WATERLOO METRO QUARTER - NORTHERN PRECINCT SSD DA (SSD-10440) | RESPONSE TO REQUEST FOR FURTHER INFORMATION

This letter has been prepared to respond to the request for further information (RFI) issued by the Department of Planning, Industry and Environment (DPIE) on 15 April 2021 regarding the Waterloo Metro Quarter (WMQ) Northern Precinct State Significant Development (SSD) Development Application (DA) (SSD-10440). The RFI was issued by DPIE following their review of the Response to Submissions (RtS) report submitted by the applicant on 9 April 2021.

ATTACHMENT 1 – Residential Food Waste Caged Area

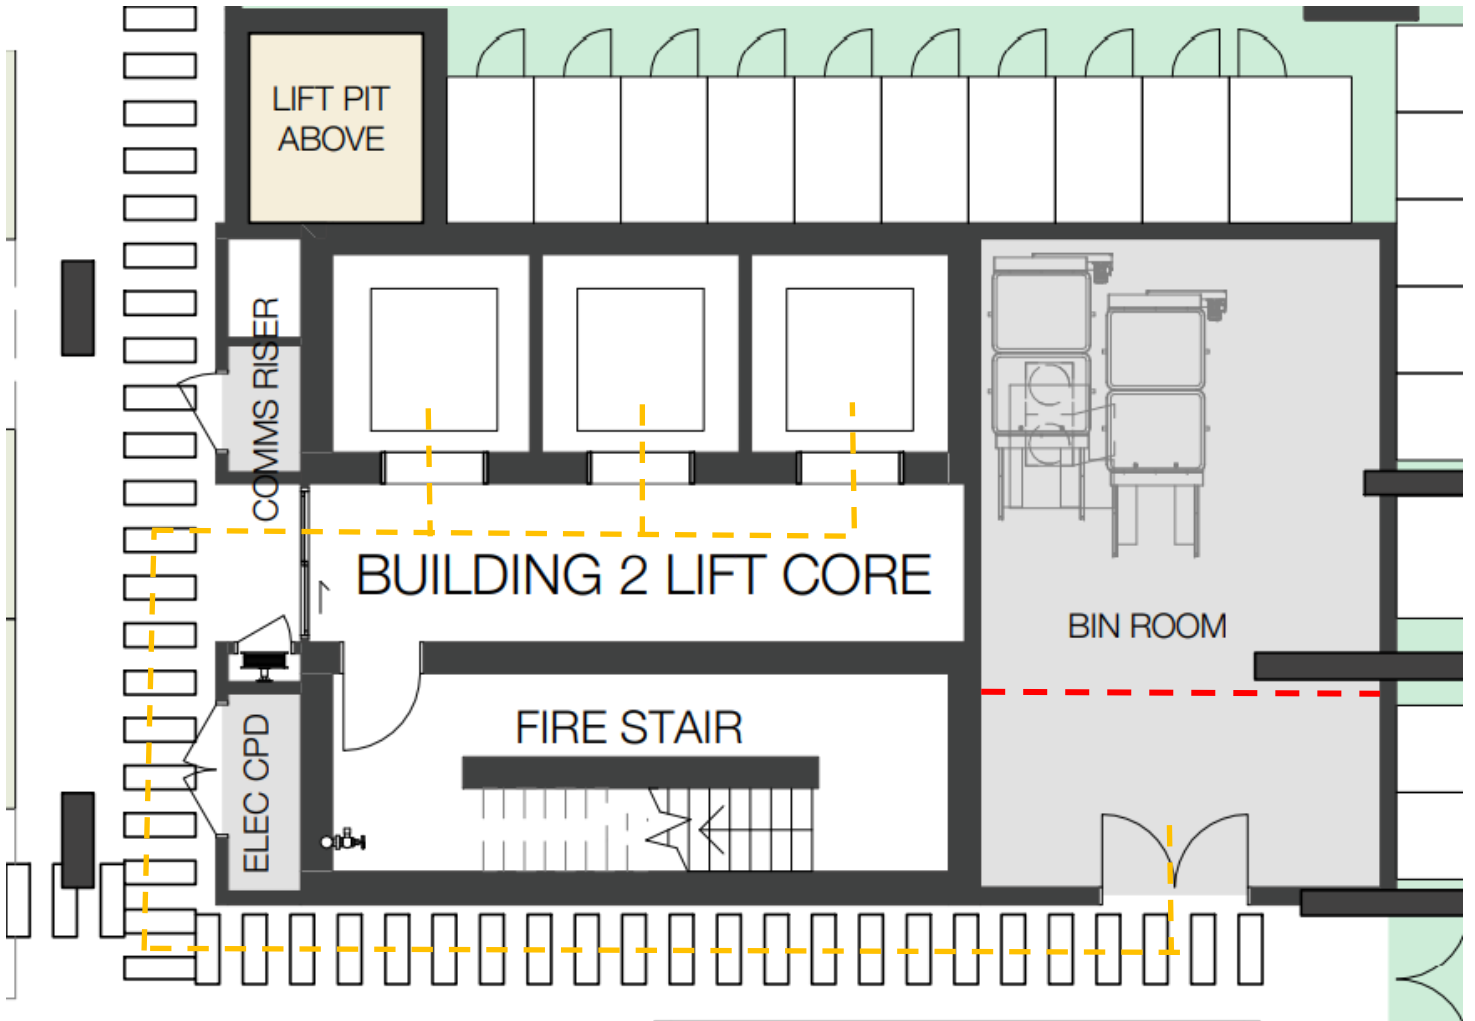
The following is noted with regards to other matters raised by Council pertaining to food waste, further details on ongoing management and the preparation of construction and demolition WMPs:

- Food waste is already separated for the retail and commercial component of the development, which is relevant for Building 1.
- For Building 2, food waste is currently captured within the normal waste stream and therefore the development is capable of accommodating food waste generation. If Council's service is confirmed in the future, three 1100L bin can be converted to 13 x 240L bins for food waste.

- This would require all building occupants to store their food waste in eco-friendly bags and then transport them down via the lift into the waste room where the 240L bins are located. These 240L bins will be caged off from all other bins and equipment.

SECTION D 1:50
L13 COMMUNAL TERRACE

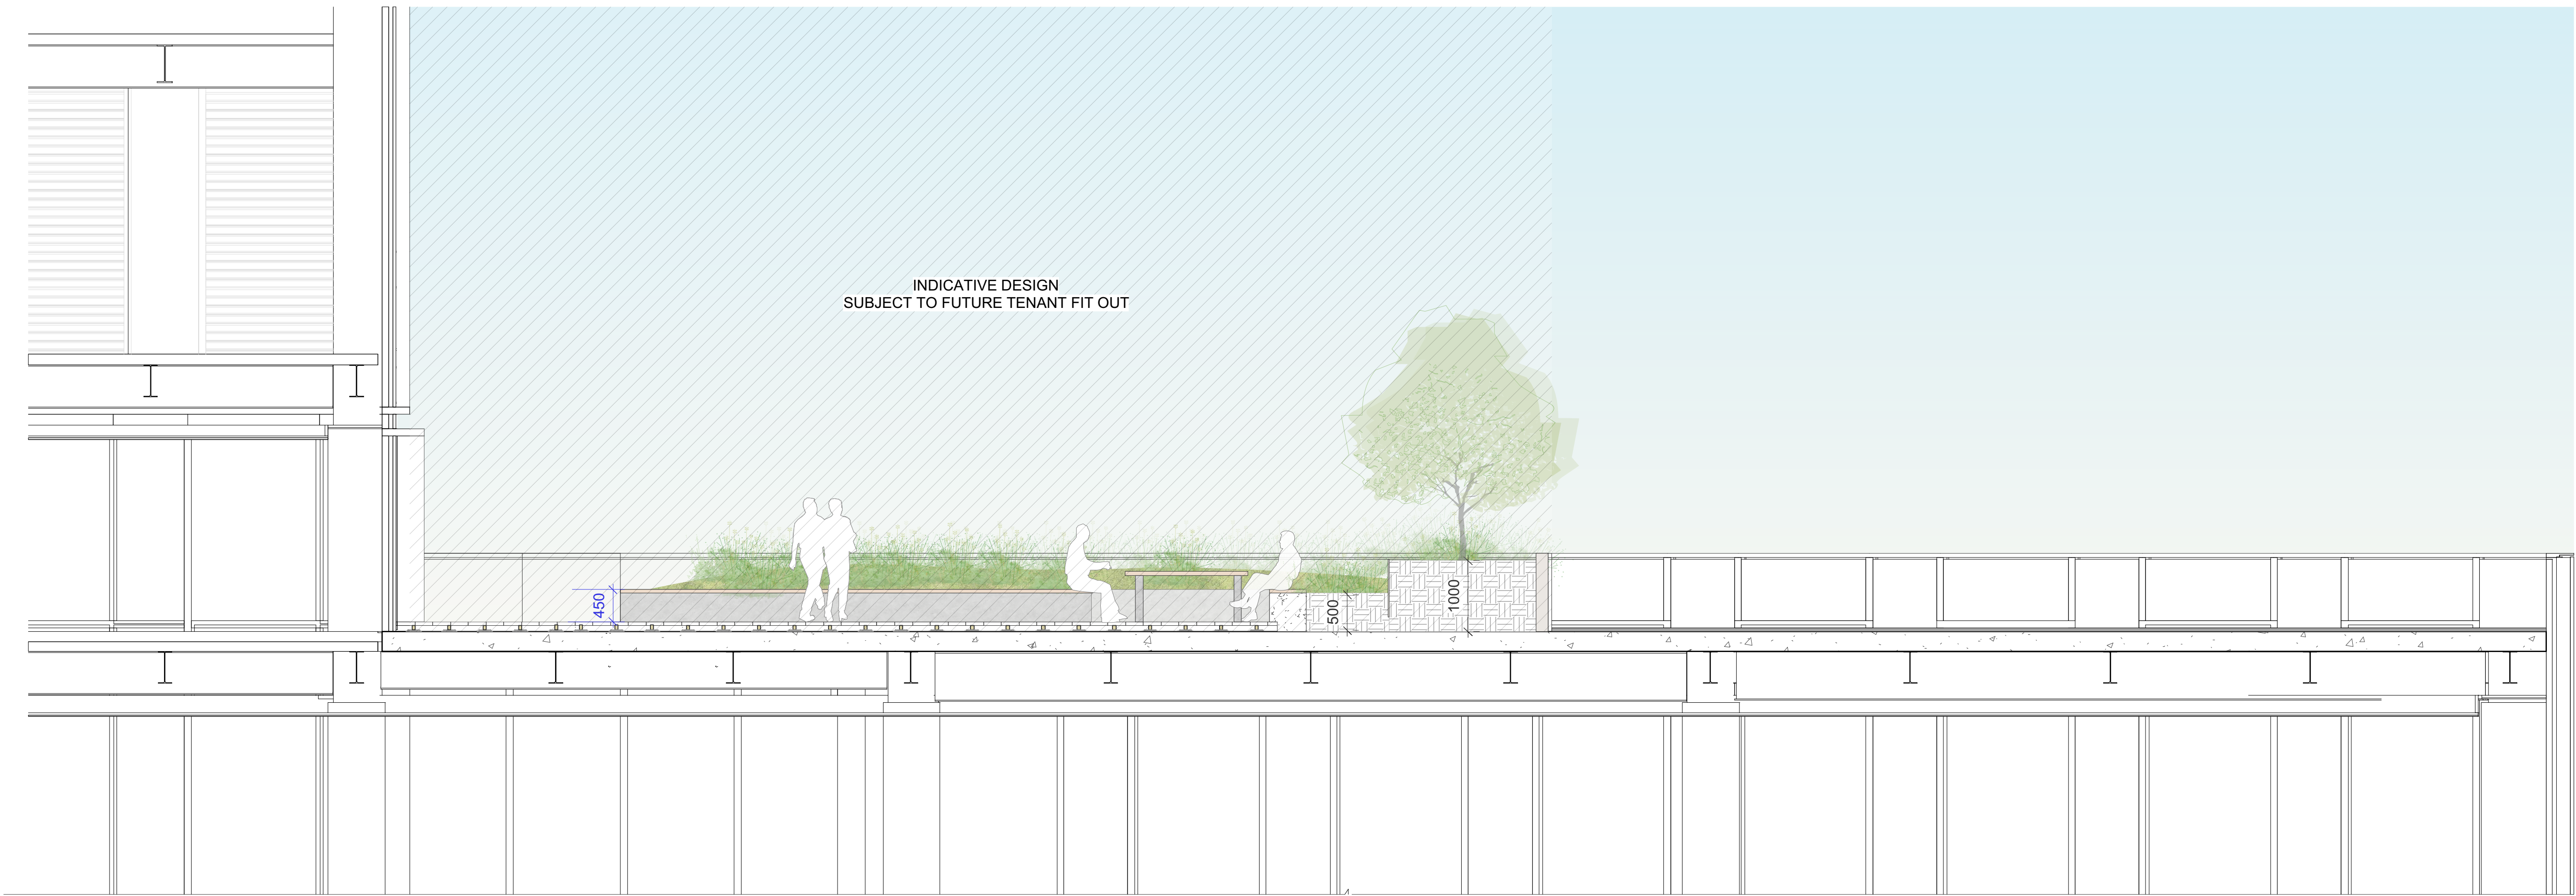
Council indicated that they do not support the proposed soil mounding to the Level 13 communal terrace to achieve the required soil depth and recommended that the wall height be increased to these planters, limiting mounding to 300mm maximum.

Aspect have prepared a revised section drawing for the Level 13 communal terrace which accompanies the landscaping response provided at **Attachment C**. The design of the terrace has been amended and no longer relies soil mounding to achieve the required soil depth. In accordance with the '*Landscape Code Vol 2 – Planting on Structures*', the amended design incorporates a minimum soil depth of 900mm which is provided as part of a large continuous planter to support small trees ranging from 4 to 6 metres in height.

Figure 2. Shelter areas and evacuation route - Northern precinct (ground level)

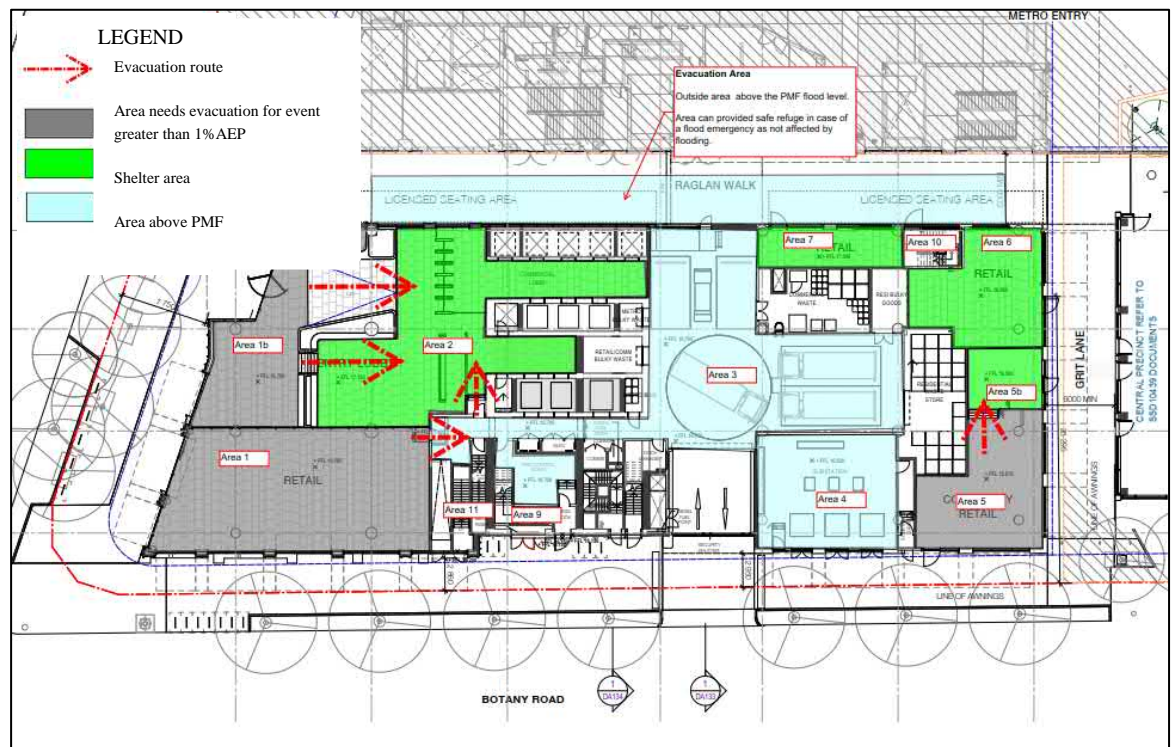
The comments received from the EES Group relate to flood emergency response management, specifically requesting the applicant consider a range of storm durations and the timing of flooding in relation to evacuation to inform appropriate flood emergency response management.

As outlined within **Attachment D**, an evacuation strategy for occupants of the ground floor of the Northern Precinct includes designating shelter areas within higher levels of the development where occupants can remain safe by sheltering in place until the end of the flood emergency. The capacity of each sheltering area has been considered based on the number of persons anticipated within commercial lobbies, basement, and each ground level retail tenancy, with an average split between front of house and back of house areas within the tenancy, and the expected occupancy of both retail staff and patrons.
